**Re: Office/Warehouse for McClintic RDM, 9700 Trumbull Ave SE,  
Traffic Circulation Layout  
Architect's dated 5-22-14 (L20-D051)**

Based upon the information provided in your submittal received 5-27-14, the above referenced plan cannot be approved for Building Permit until zoning signs off on TCL and the following comments are addressed:

SITE PLAN
SCALE: 1" = 20'-0"

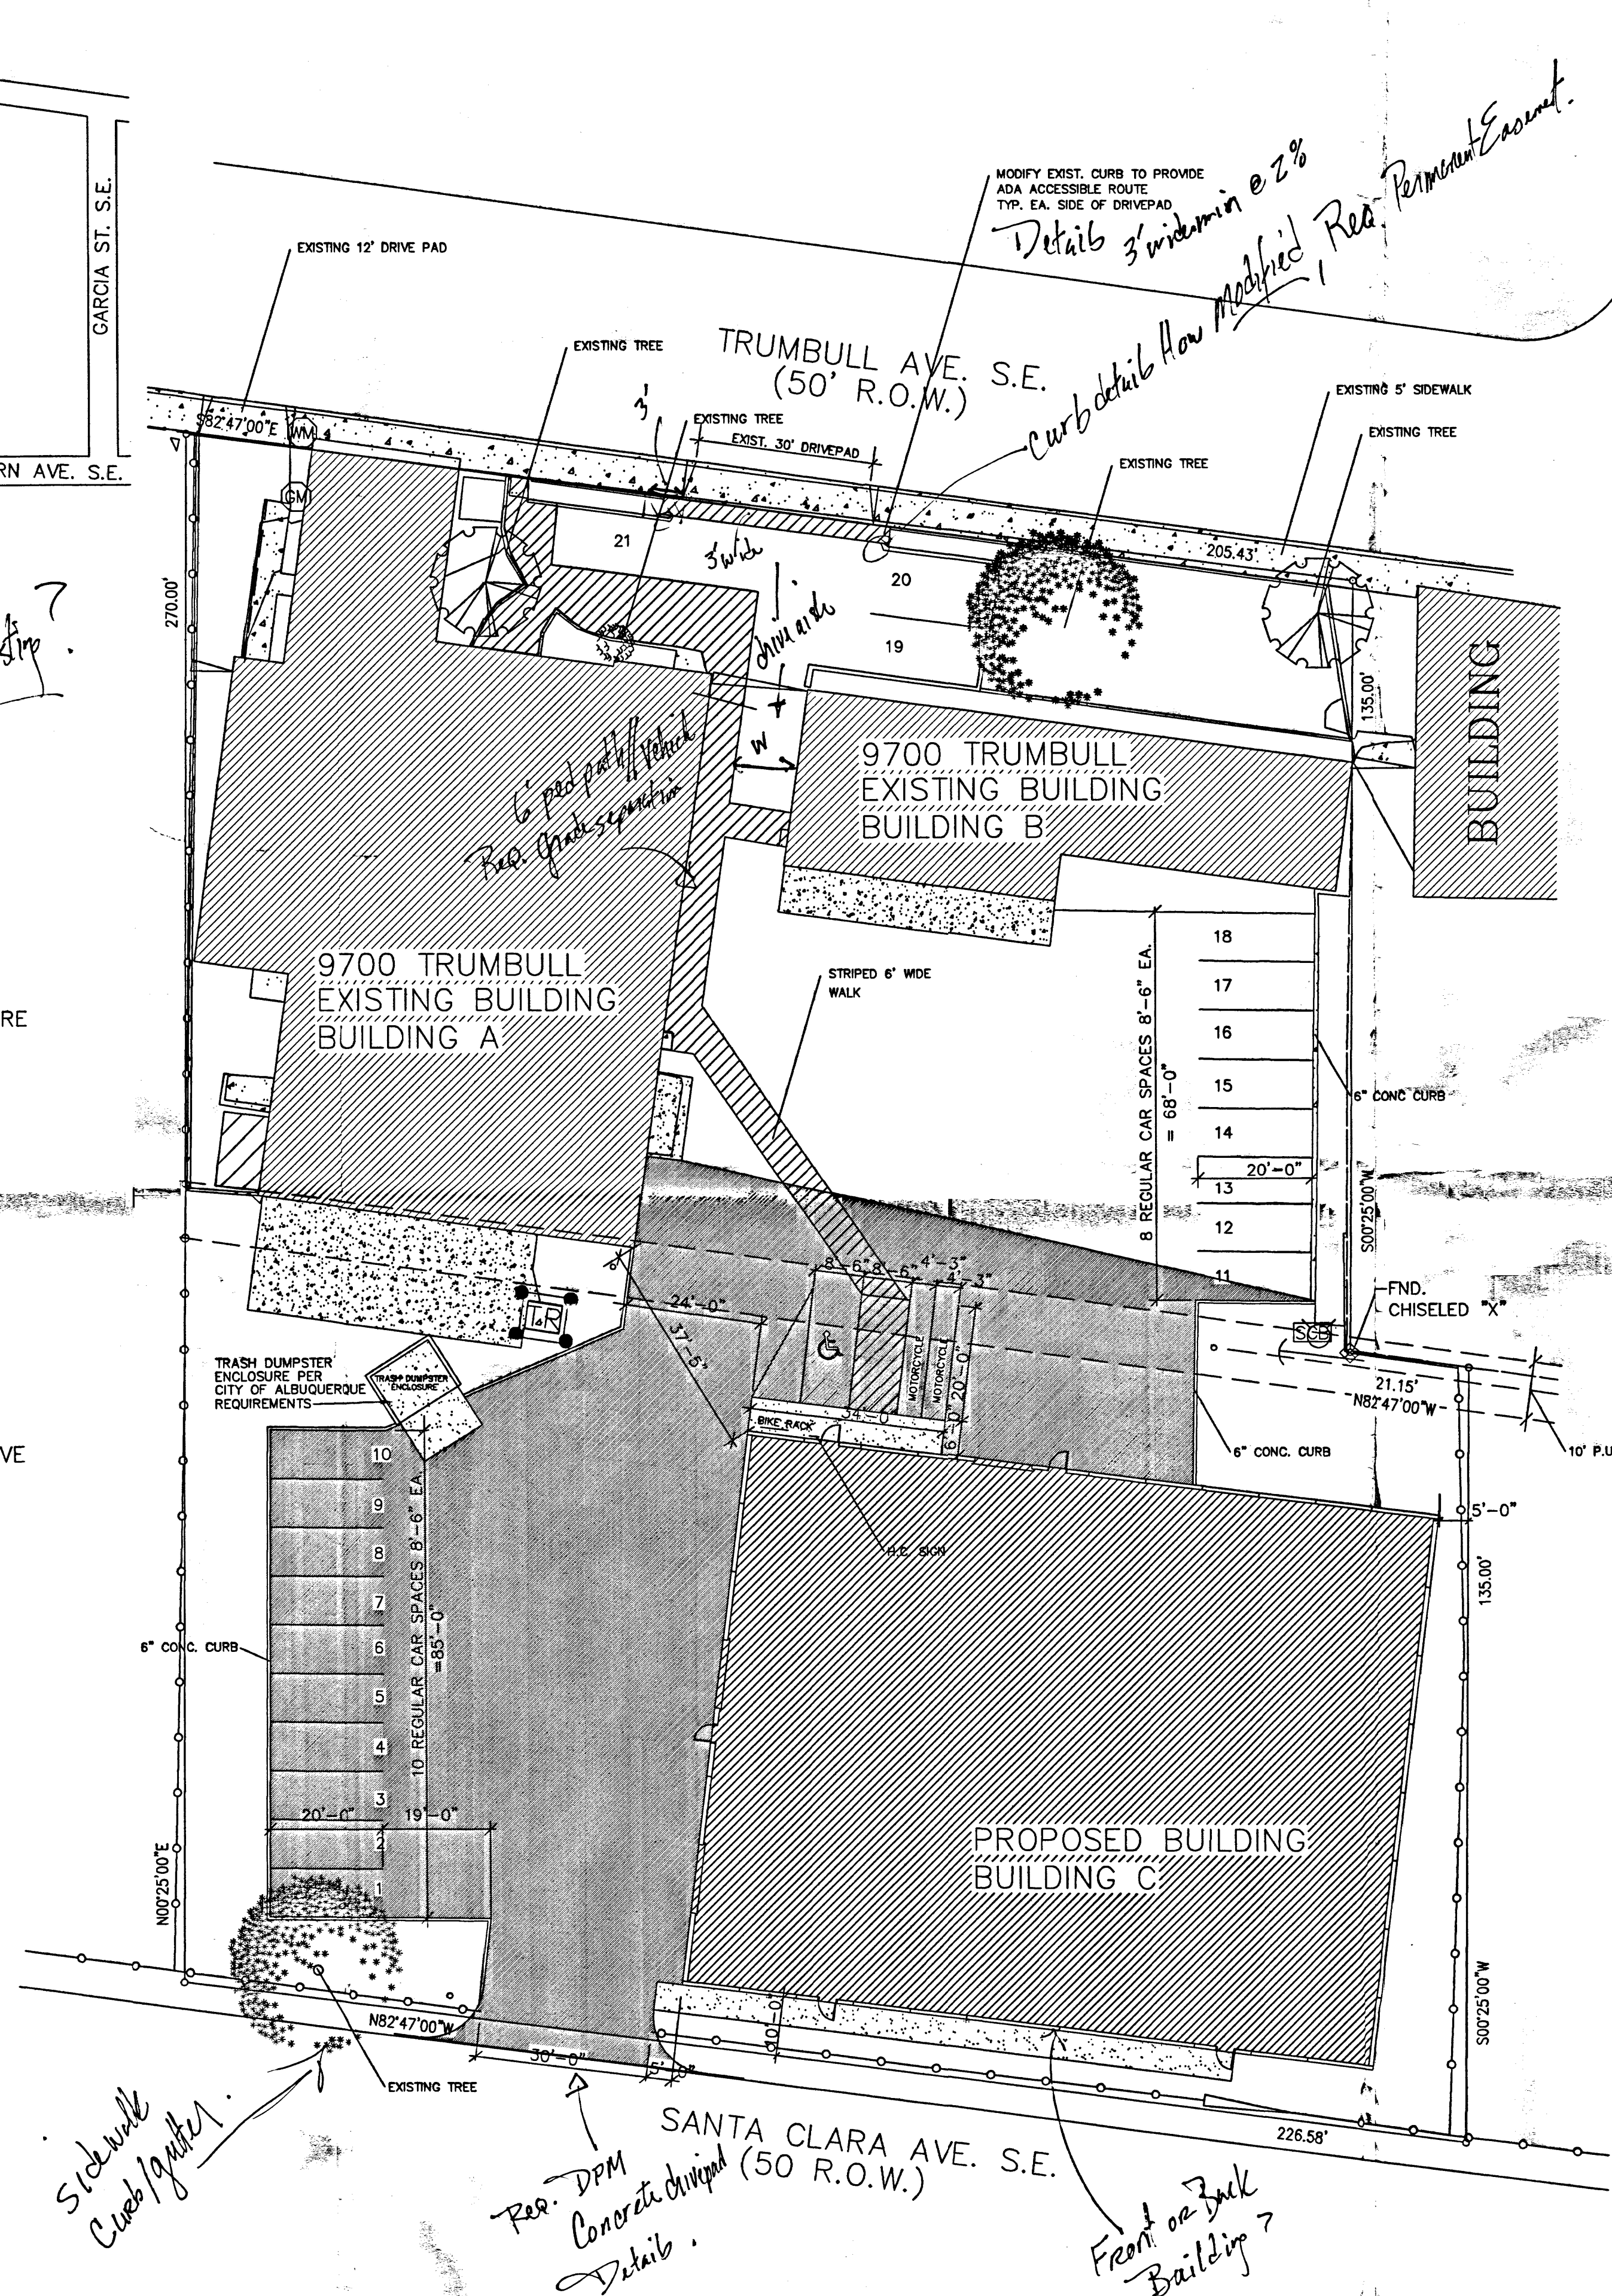
3. The proposed 6 ft wide striped pedestrian walkway from the COA ROW to the building entrances is not DPM compliant. Pedestrian pathways situated parallel to vehicular traffic must be protected by an elevation change.

4. Please dimension width between building A & B. What is the vehicular drive aisle width?
5. All drivepads crossing city sidewalks must provide ADA access per DPM and East Gateway SDP (5.6.1.C.4.c, p5-46) The proposed striping and modified landscape curb to incorporate an ADA pedestrian path, set back of existing drivepad on Trumbull, requires greater detail to demonstrate compliance.

6. The proposed sidewalk to back of drivepad is outside of COA ROW. A permanent Sidewalk Easement will be required with proposed sidewalk.
7. Provide details or refer to the appropriate city standard for proposed 30 ft wide drivepad on Santa Clara.

8. Sidewalk, curb and gutter are required along the frontage of Santa Clara Ave. Label and provide appropriate city standards for infrastructure improvements. A formal variance request to the current Traffic Engineer, Kristal Metro P.E., is required if the development can justify reason(s) for non-compliance with the DPM guidelines.

9. According to Zoning, landscaping is required with the addition of proposed 12,000 SF building C . Please provide landscaping plan with next
